RFI Response Letter

Apollo Place Data Centre (SSD-67407231)
1 Apollo Place and 1 Sirius Road, Lane Cove West

**RE: APOLLO PLACE DATA CENTRE (SSD-67407231)
REQUEST FOR ADDITIONAL INFORMATION**

Figure 3-1: Site location, most-affected residential and commercial assessment receiver locations, land uses and NCAs

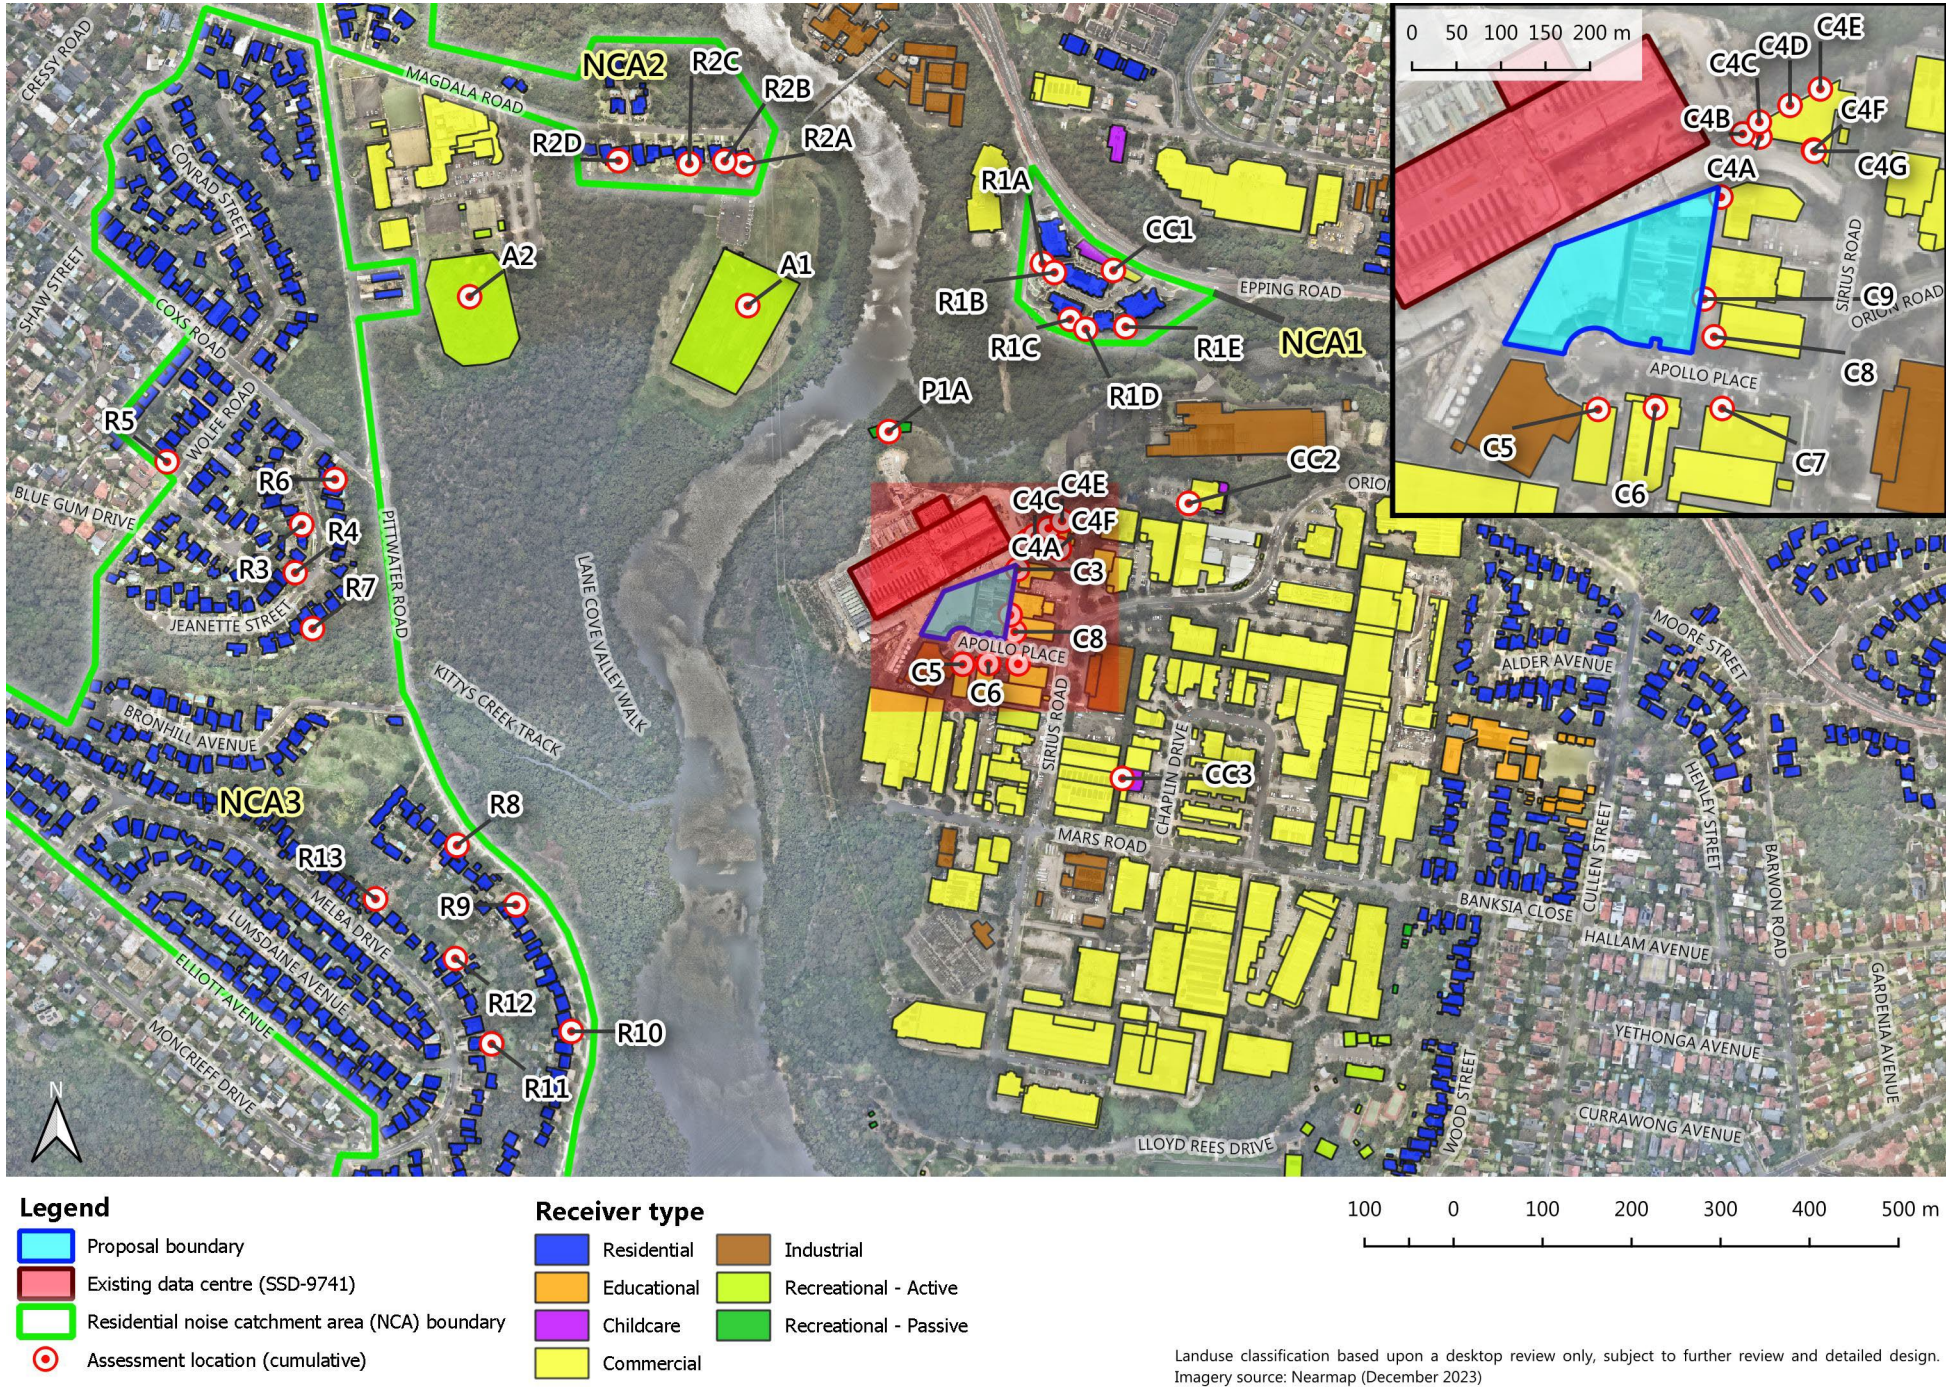
- a) cumulative noise levels at all potentially most-affected residential and commercial receivers, incorporating predicted noise contributions from both the approved form of SSD-9741 and proposed Apollo Place data centre, both with and without back-up generator tests associated with the proposal*
- b) a detailed evaluation of low-frequency noise for all proposed operations (excluding emergency operations), in accordance with Fact Sheet C of the Noise Policy for Industry*
- c) details of all source and pathway controls required to achieve compliance with the existing noise limits specified in Condition B14 of the SSD-9741 consent.*

Note that for the purposes of preparing the updated noise assessment, the noise limit at surrounding commercial receivers is to be taken as LAeq,15min 63 dB(A), consistent with the limit at 1A Sirius Road.

- a) Cumulative noise levels at all potentially most-affected residential and commercial receivers are presented in Section 3.3 and Tables 3.1 and 3.2. This includes updated predictions for back-up generator maintenance testing for the Proposal combined with the existing data centre noise predictions incorporating the latest detailed design operations and acoustic strategies.
- b) & c) A detailed evaluation of low-frequency noise for all proposed operations is included in the predictions detailed in Section 3.2, with the appropriate low-frequency adjustment added where indicated to the predicted noise level before comparing against the criteria, in accordance with NPfI Fact Sheet C.

Cumulative noise levels at all potentially most-affected residential and commercial receivers are presented in Section 3.1 and 3.3. These cumulative predicted noise levels include the latest detailed design operations and acoustic strategies for the existing data centre as detailed in 3.1, and revised maintenance testing modelling for the Proposal as detailed in 3.1.

With these updated predictions for the latest detailed design operations and acoustic strategies of the existing data centre, noise levels are predicted to achieve compliance with the existing noise limits specified in Condition B14 of the SSD-9741 consent, except at P1 during existing data centre (SSD 9741) worst-case daytime generator testing, and C3 during Proposal worst-case daytime generator testing. These residual impacts are further addressed in Section 3.4
